City of Portland, Maine - Building or Use Permit Application
 389 Congress Street, 04101 Tel: (207) 874-8703, Fax: (207) 874-8716

| Permit No: 06-0784 | Issue Date: | CBL: 012 A005003 |

| Location of Construction: 145 ANDERSON ST | Owner Name: HARK ROBERT S | Owner Address: 145 ANDERSON ST # 3 | Phone: |

| Past Use: Residential / Condo | Proposed Use: Residential / Condo Extend loft area over living room and extending sprinkler system to code. | Permit Fee: \$120.00 | Cost of Work: \$10,500.00 | CEO District: |

BUILDING SECTIONS

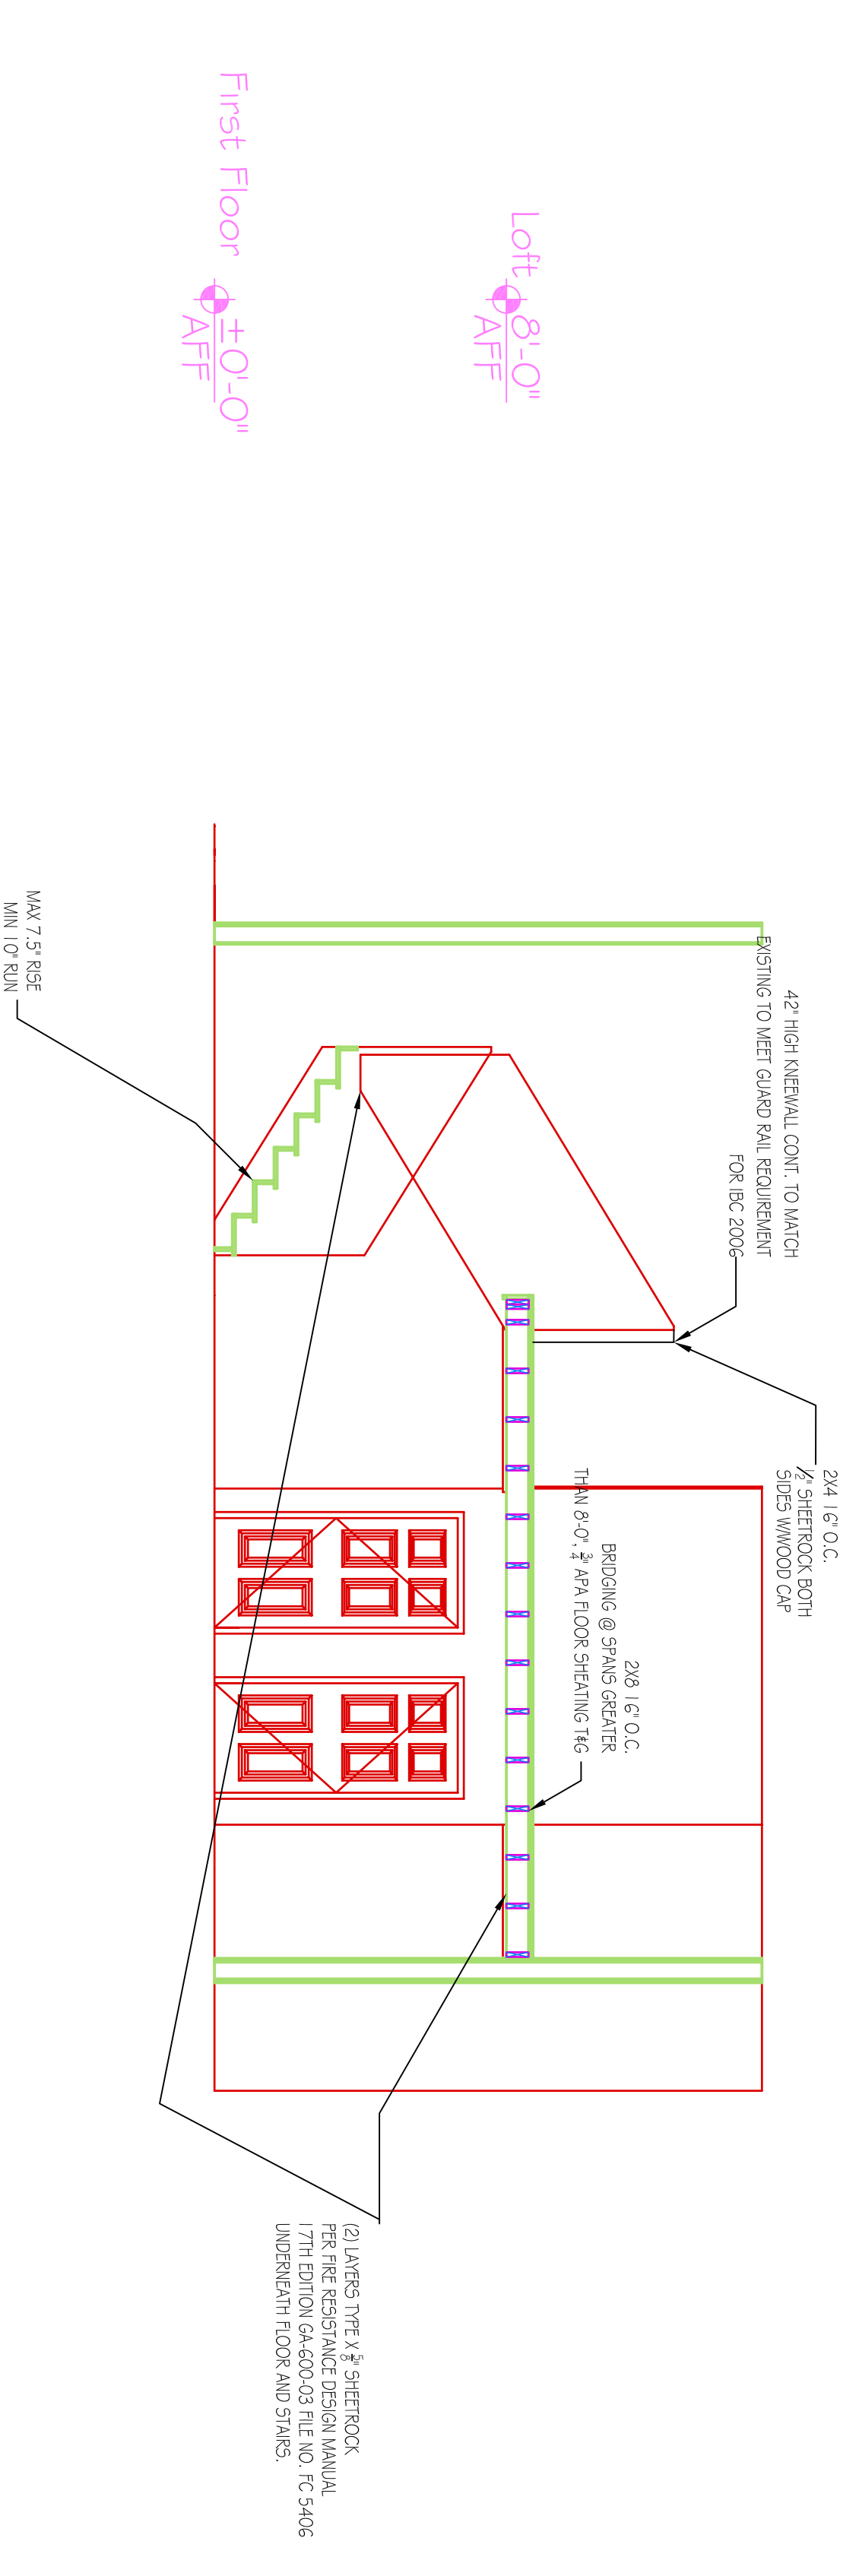
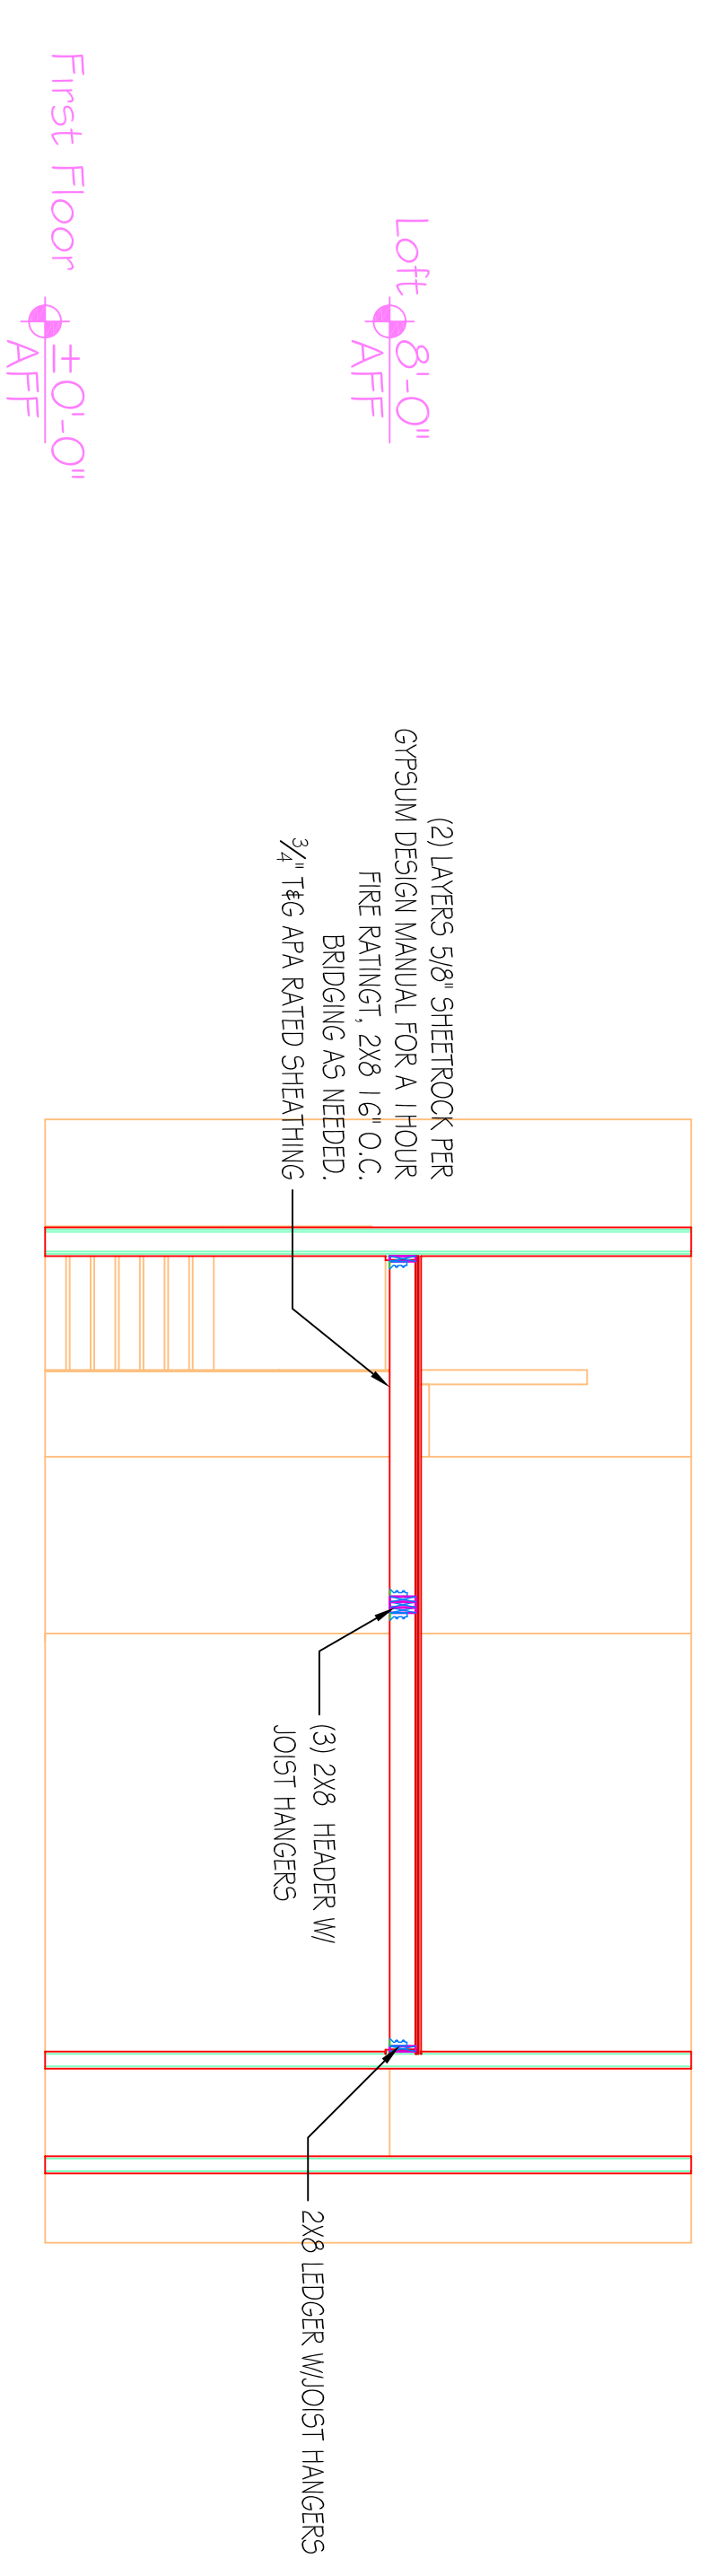
Comments:
6/15/2006-mjn: Need header and guard detail, 1 hr rated floor & stair system (type 5A construction)
